◻ North Carolina Wildlife Resources Commission ◻

March 20, 2023

Subject Scoping Comments on Replacement of Bridge No.s 155, 158, and 168 over US 23/74/19,
Haywood County. **B-5898 and B-3186**

**DETOUR EROSION CONTROL**

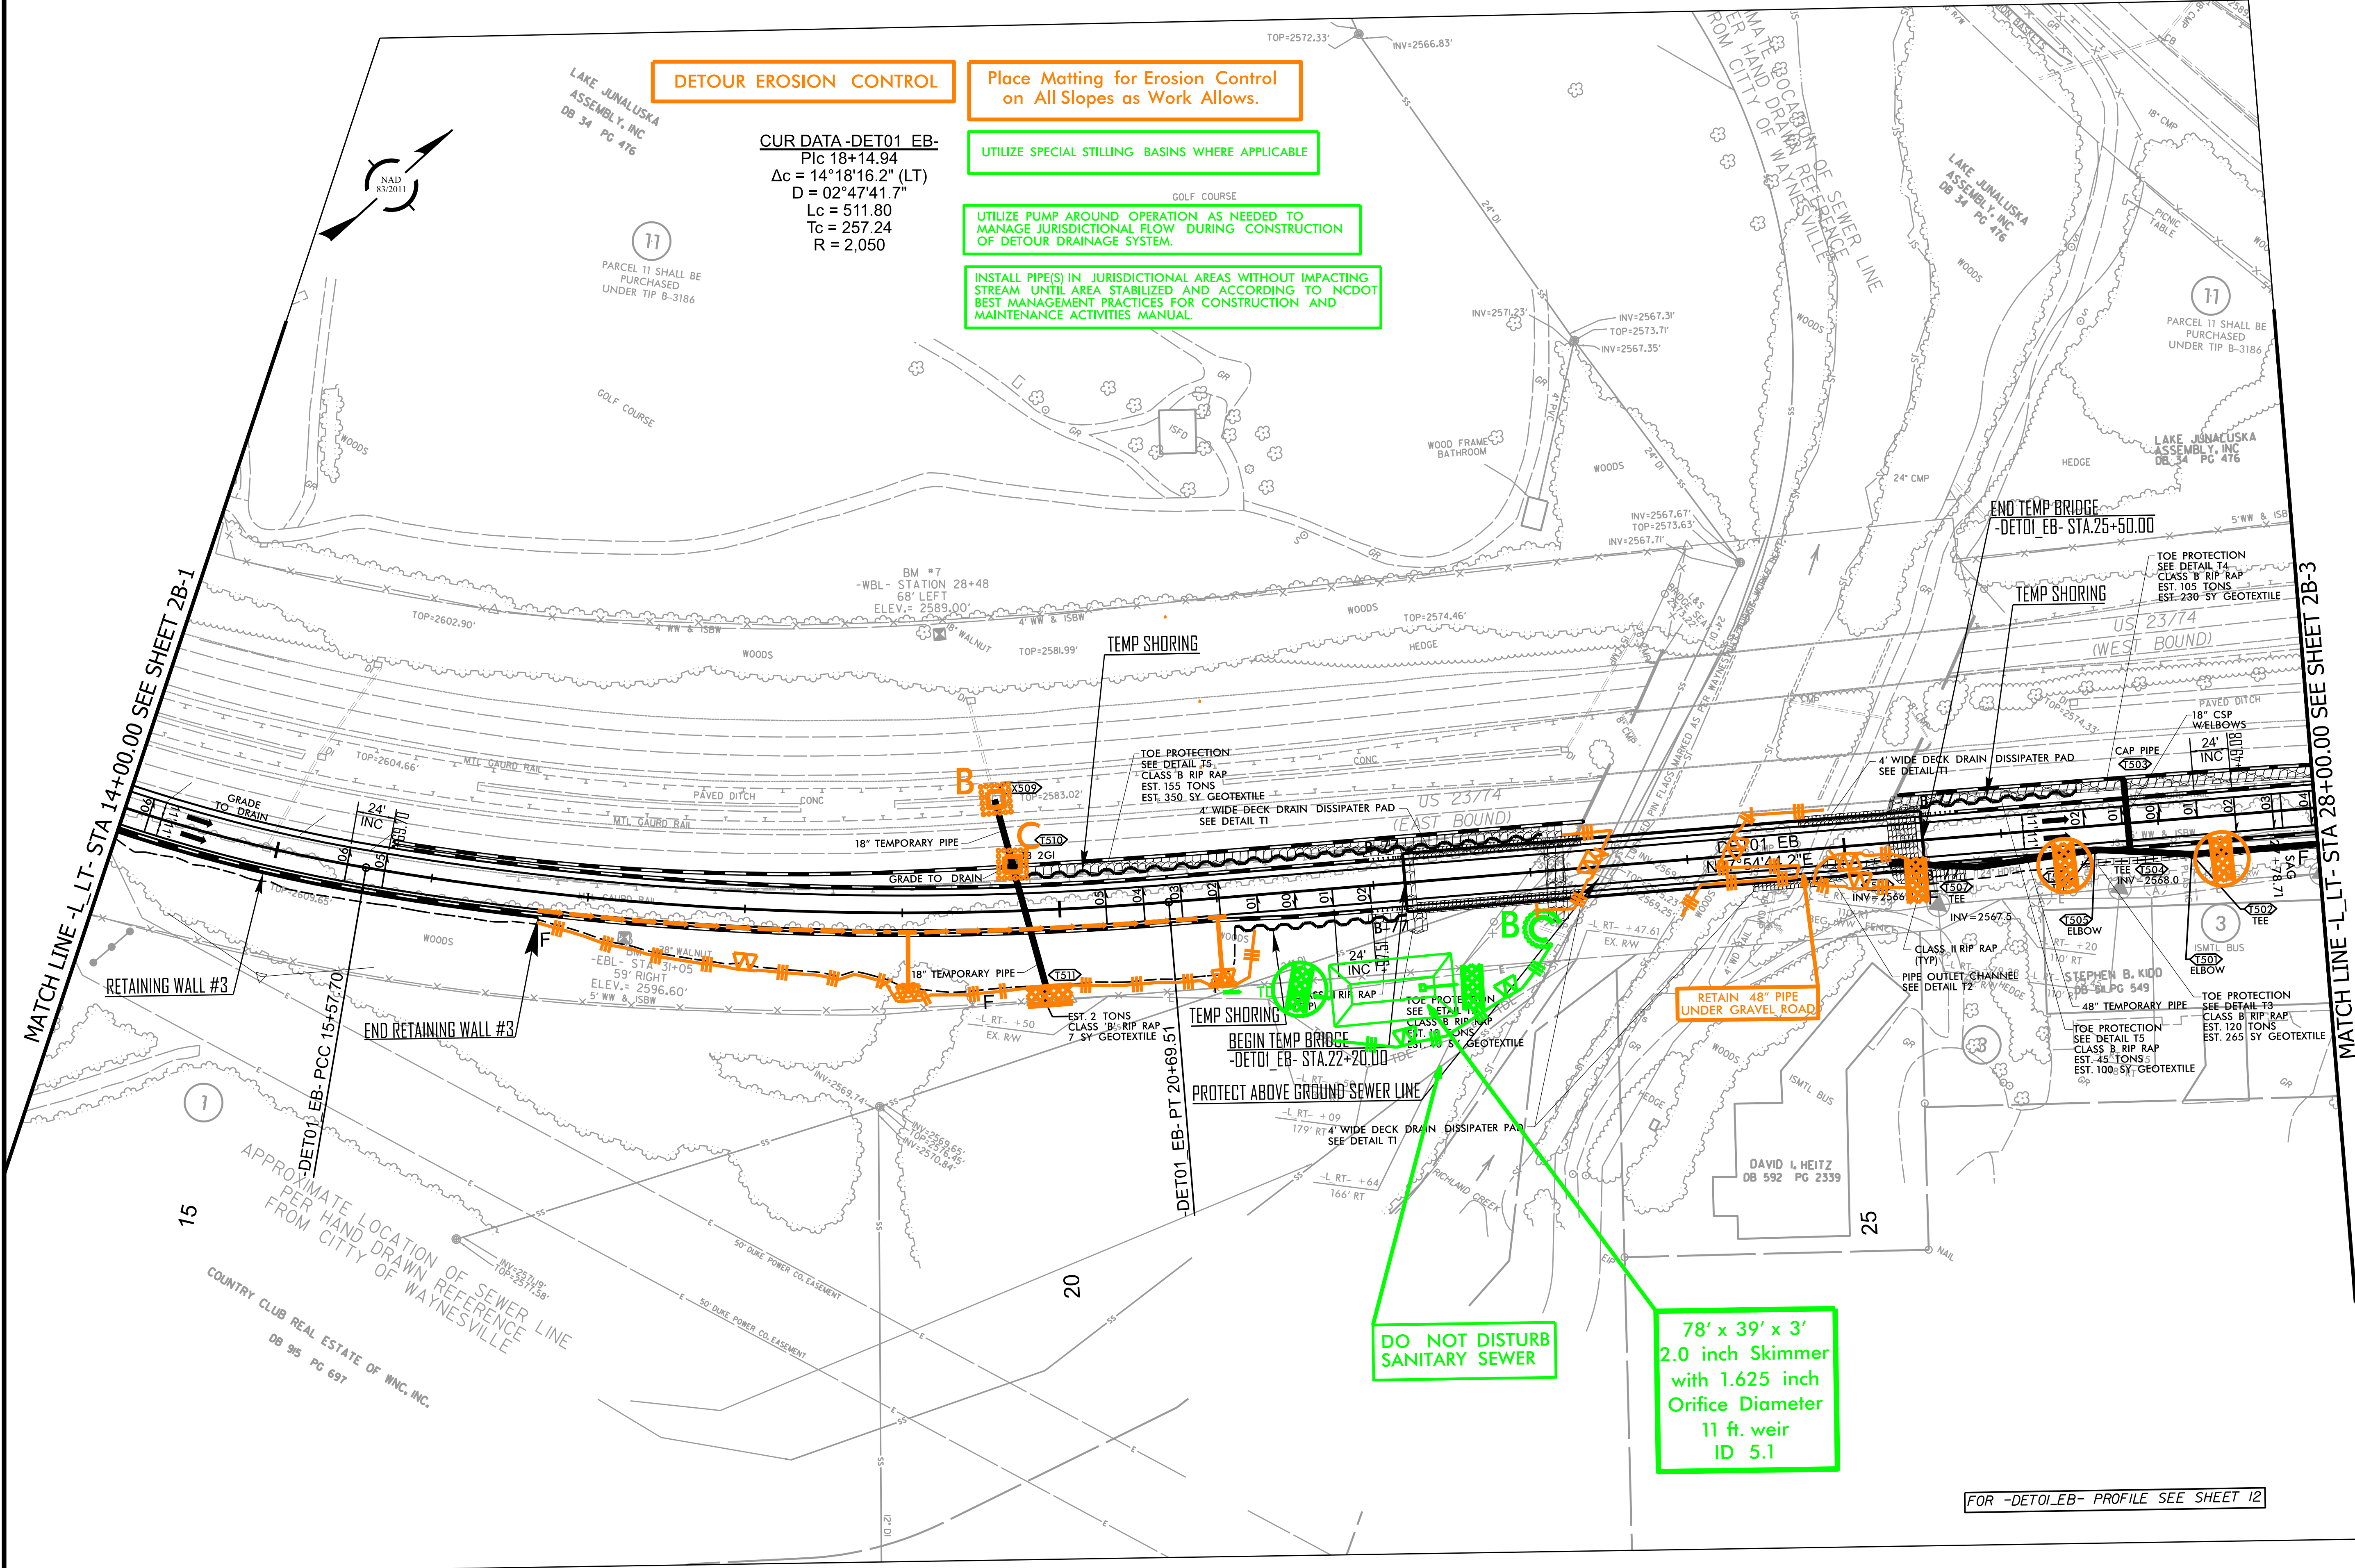
Wildlife passage under the existing bridges is likely limited, partly due to the urban environment, though small mammals and reptiles likely move along the forested riparian areas of Richland Creek. The greenway trail and rip rap-free floodplain benches allow for unobstructed wildlife passage now. Therefore, in accordance with standard recommendations, we request that the rip rap-free benching be

maintained under the new bridges. This accommodation may become more important to wildlife because the new bridges are likely to be widened to accommodate future highway widening.

STREAMBANK REFORESTATION

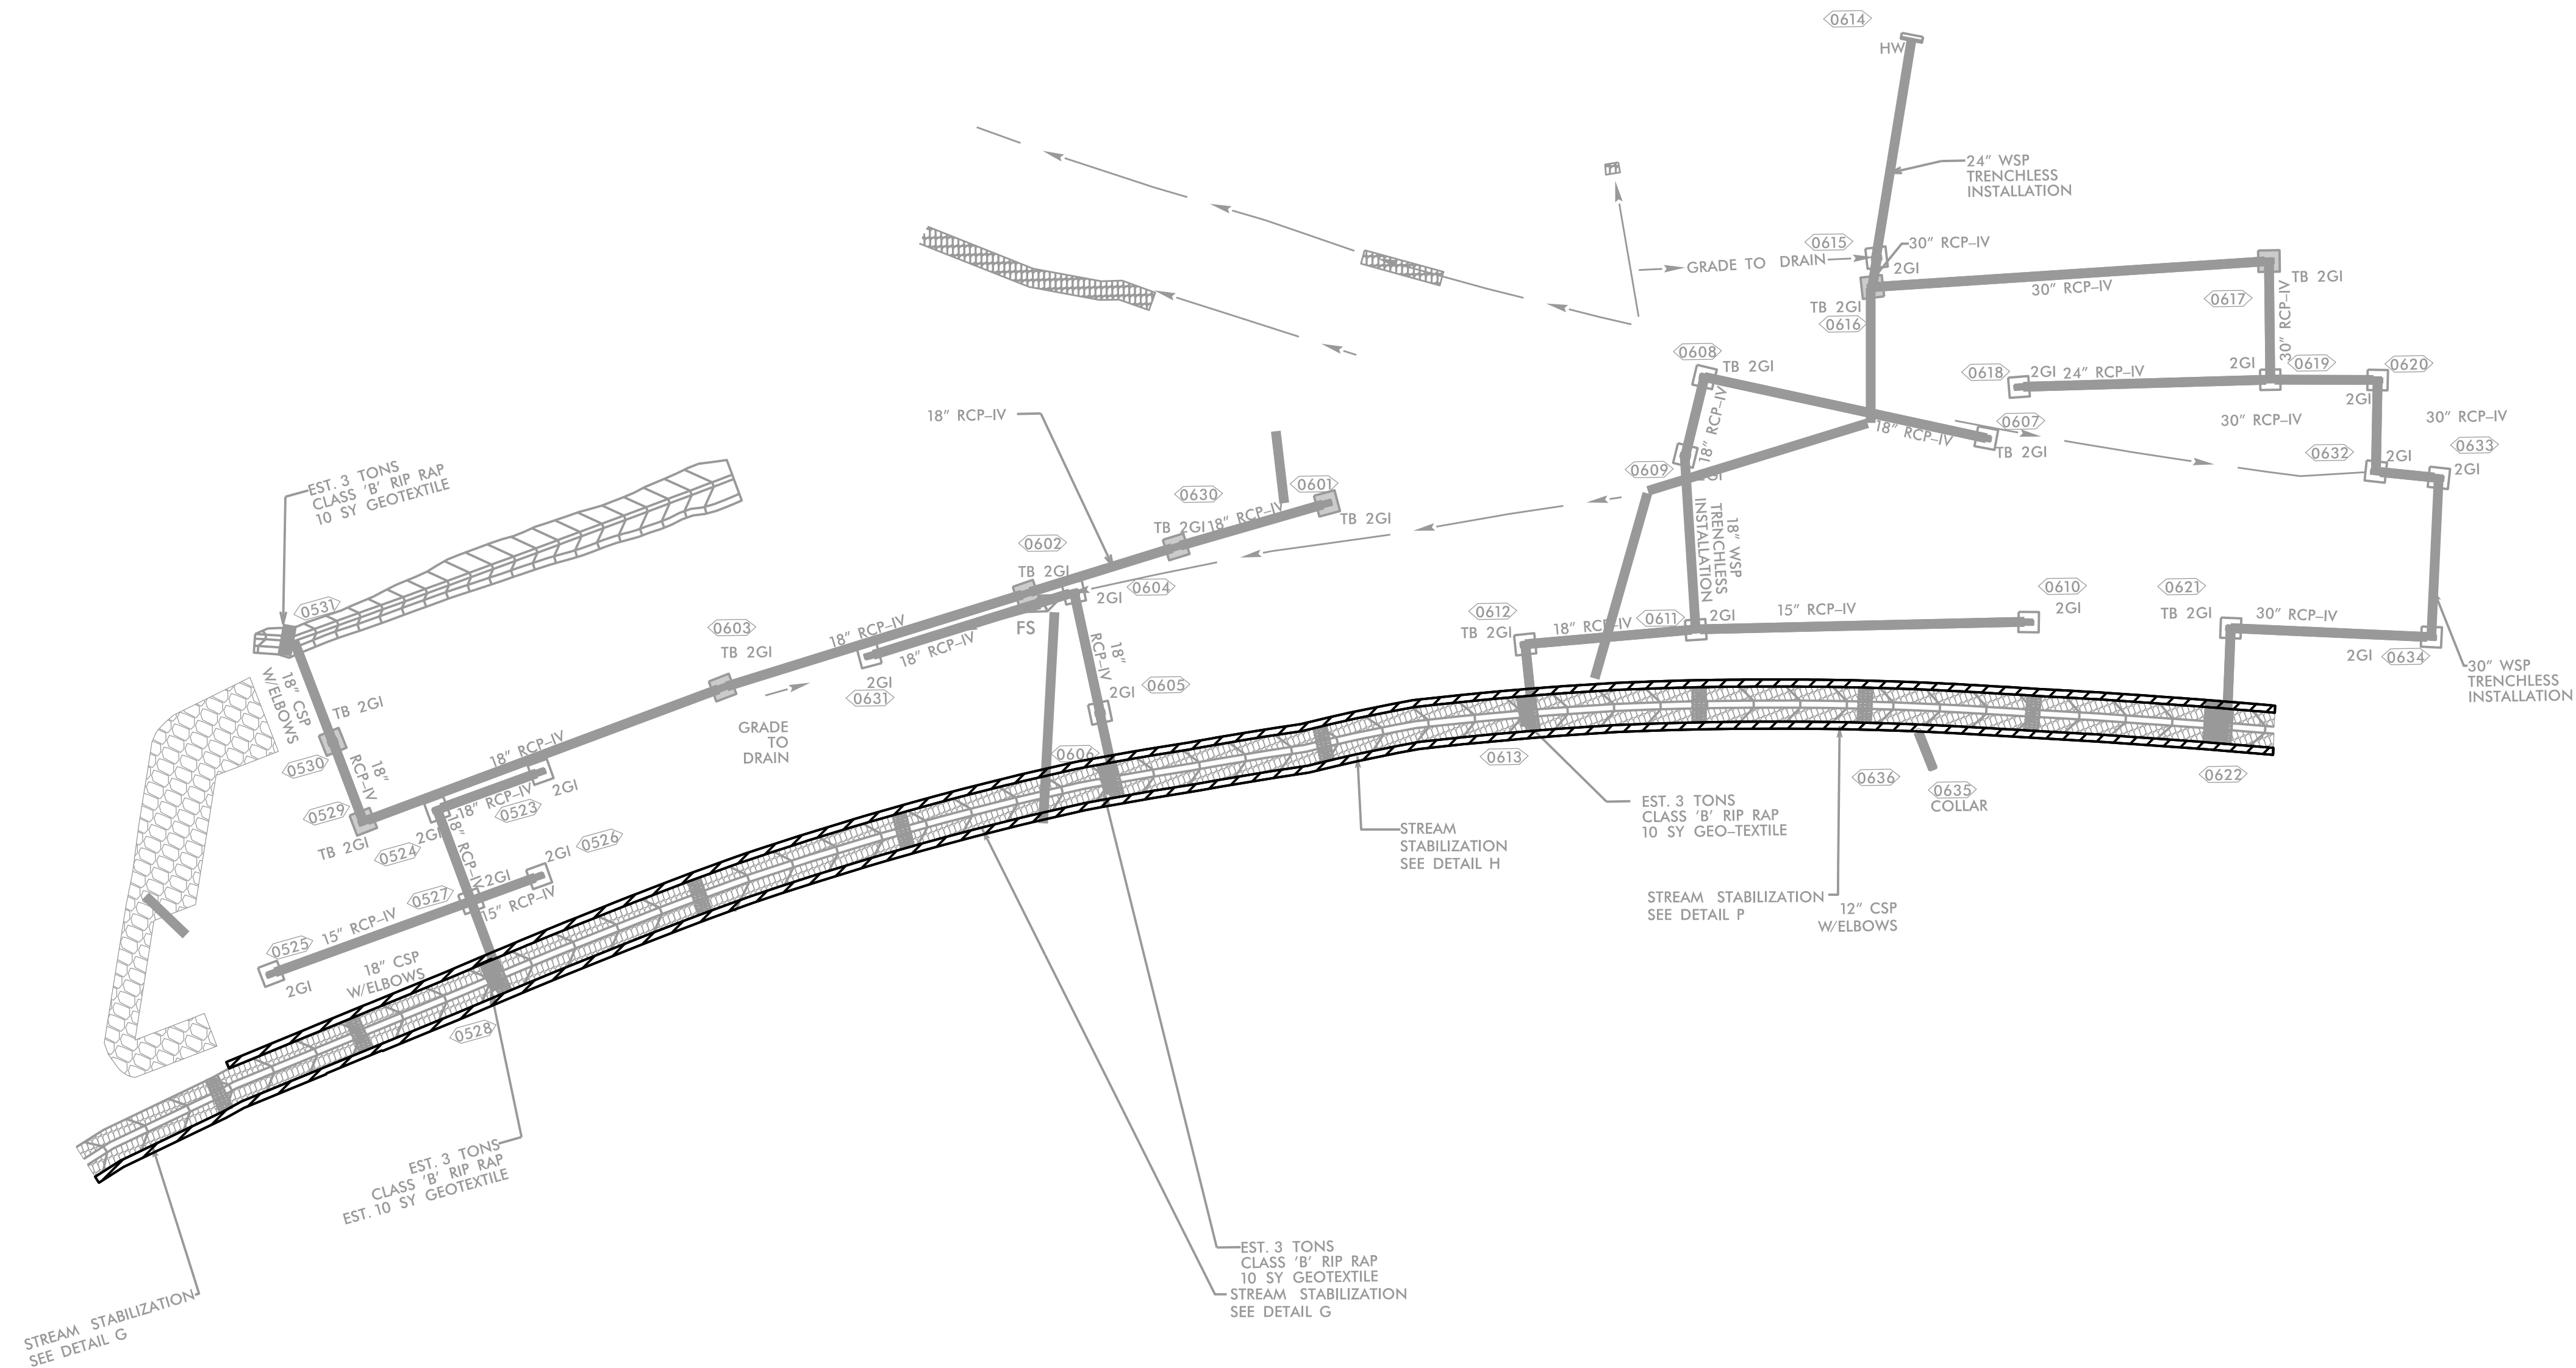
6. Temporary detours and access roads should be designed and located to avoid wetland impacts, to minimize clearing, and avoid destabilizing stream banks. Tree stumps and root mats should be left where possible under and along temporary access roads to limit streambank disturbance and promote regrowth of vegetation. Temporary fills should be removed to original ground elevations upon the completion of the project. Disturbed areas should be seeded, or mulched, and native tree species should be planted with a spacing of 10'x10'.
